Re: ***Sanctuary of Peace (El Paso County File No. PUDSP192)
MVE Project No. 61087***

This letter is in response to your March 20, 2019 comments regarding the above named project. The Wastewater Disposal Report for the project has been revised to clarify the intent of the proposed wastewater treatment systems for the development and to address your comments.

CDPHE V_2 redlines.pdf Markup Summary 10-16-2019

DEVELOPMENT PLAN
PRELIM. GRADING & UTIL.

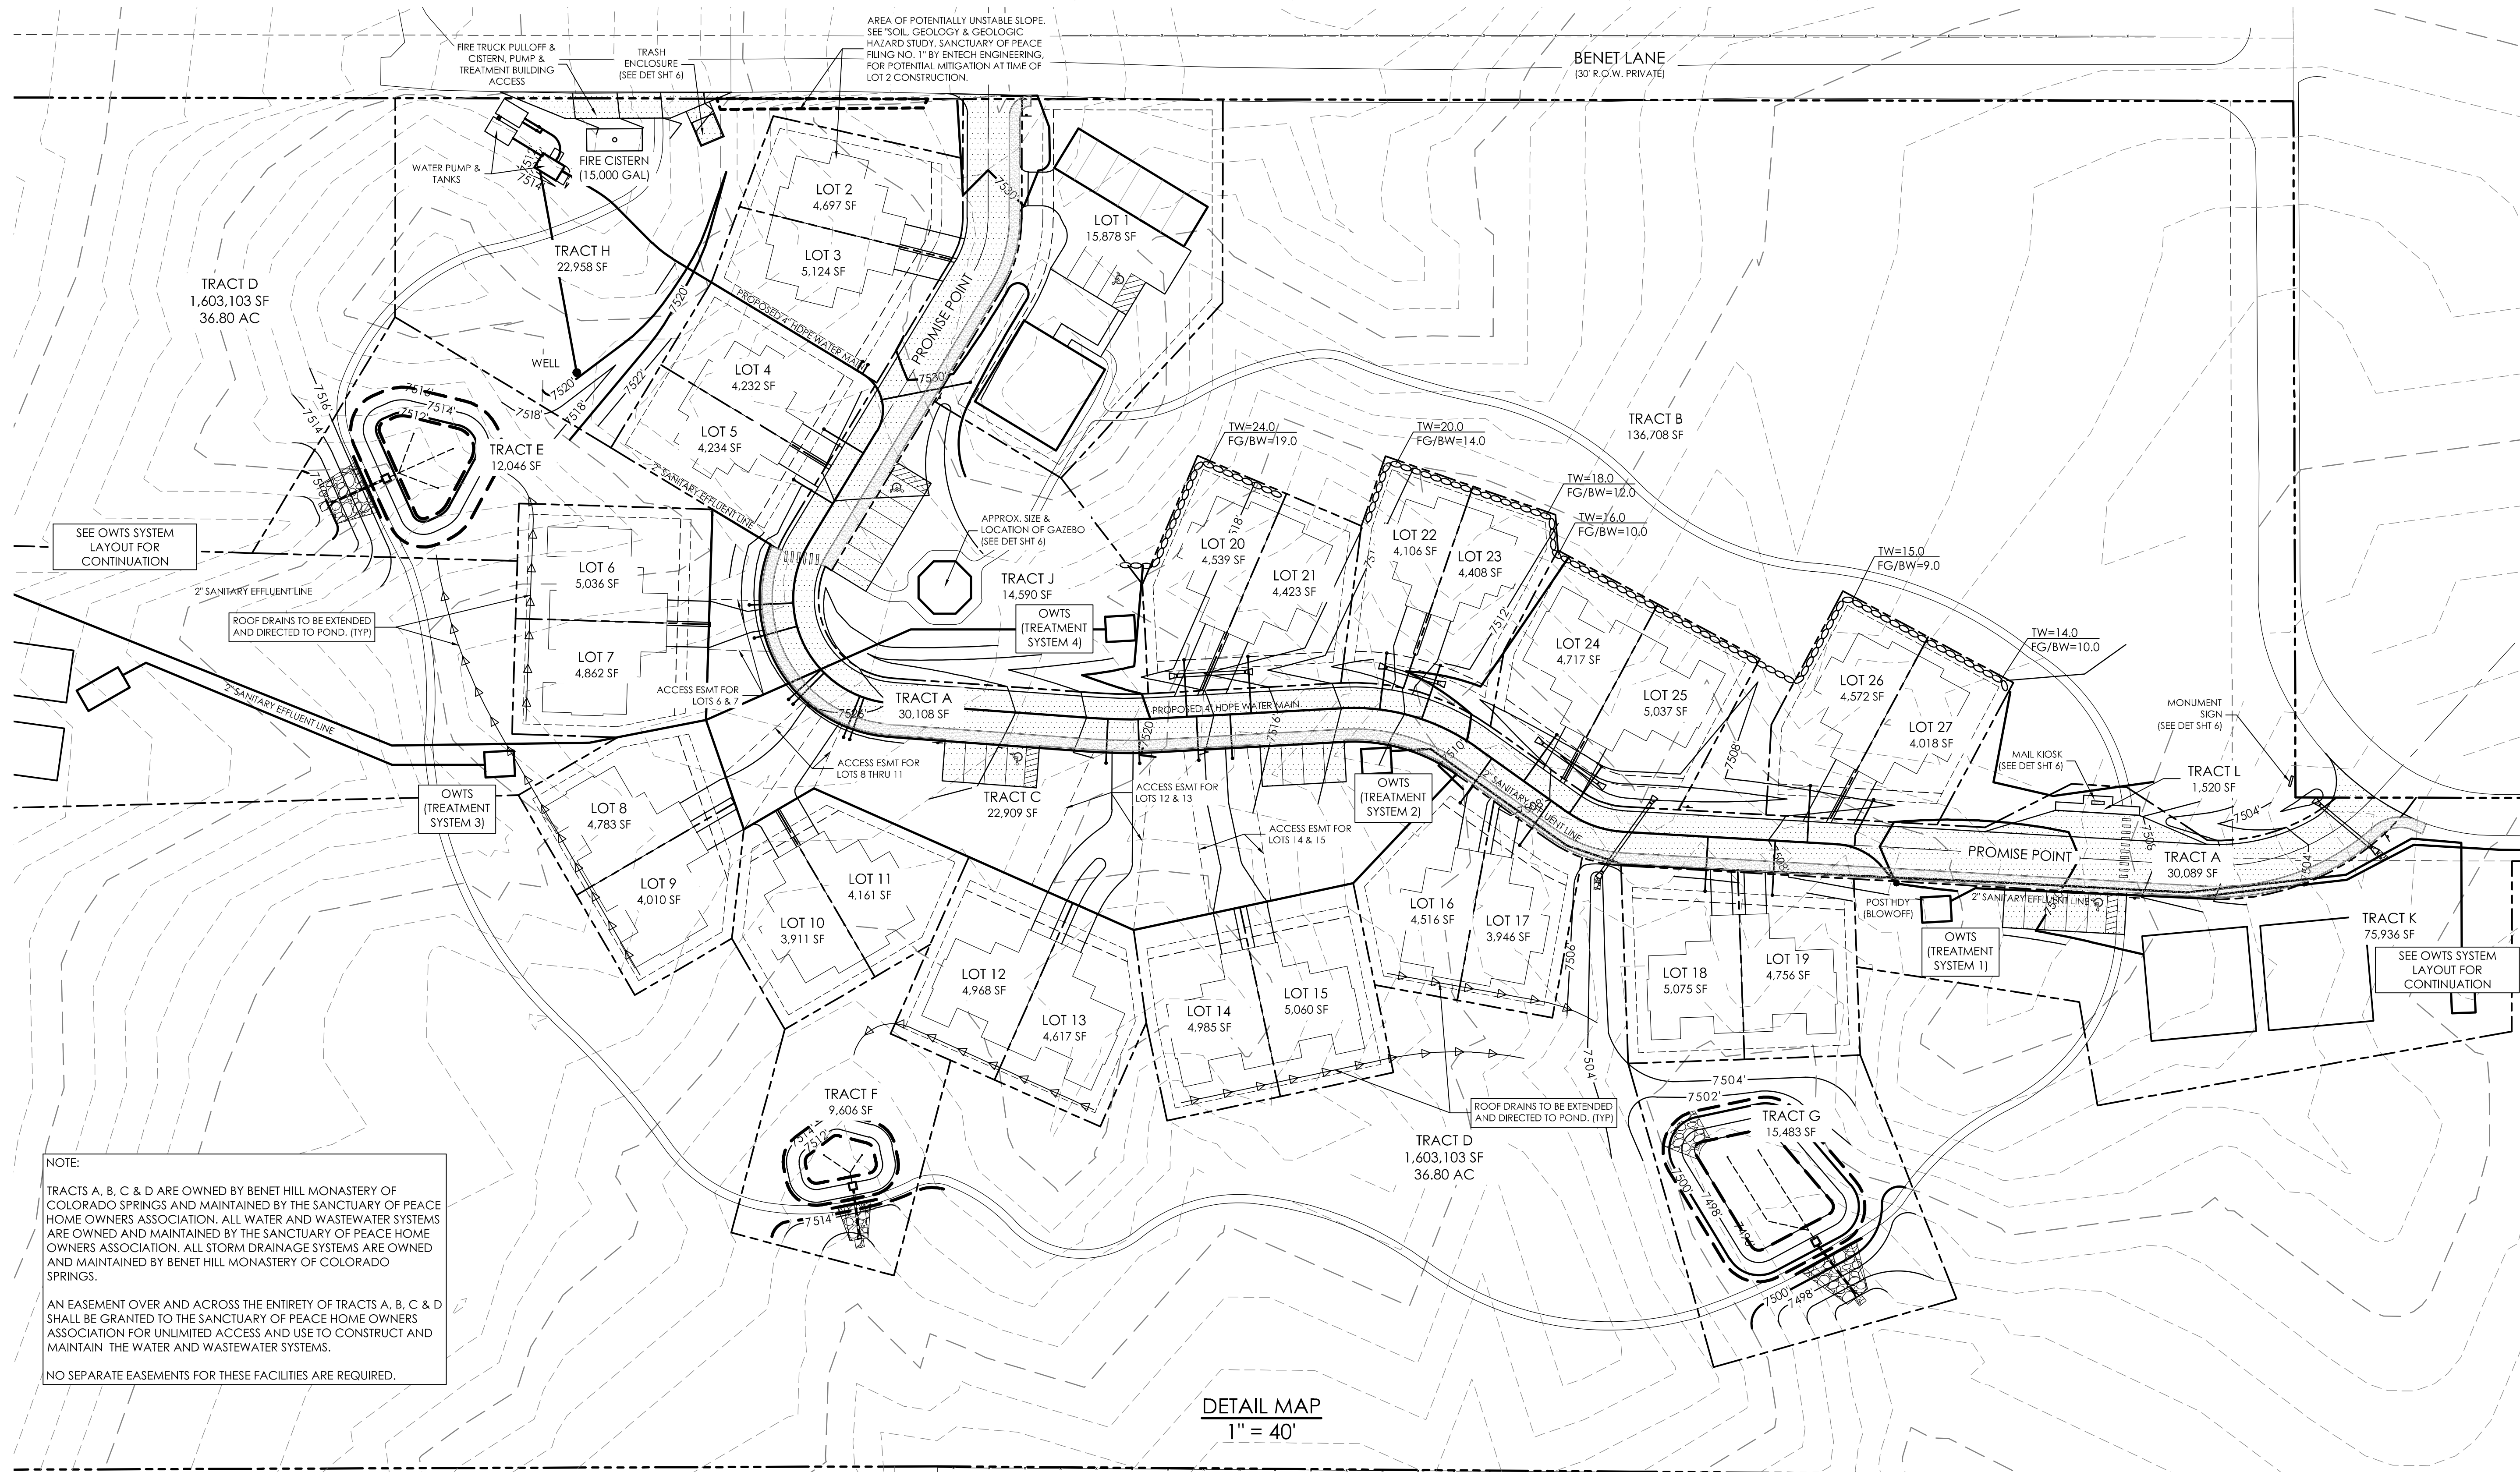
Two treatment systems are required per lot- a waiver is required if not provided; at a minimum the shared systems should be shown here and on PUDSP plan; general location is required. The well/ tanksite detail should be located on the preliminary plan and PUD.

Two treatment systems are required per lot- a waiver is required if not provided; at a minimum the shared systems should be shown here and on PUDSP plan; general location is required. The well/ tanksite detail should be located on the preliminary plan and PUD.
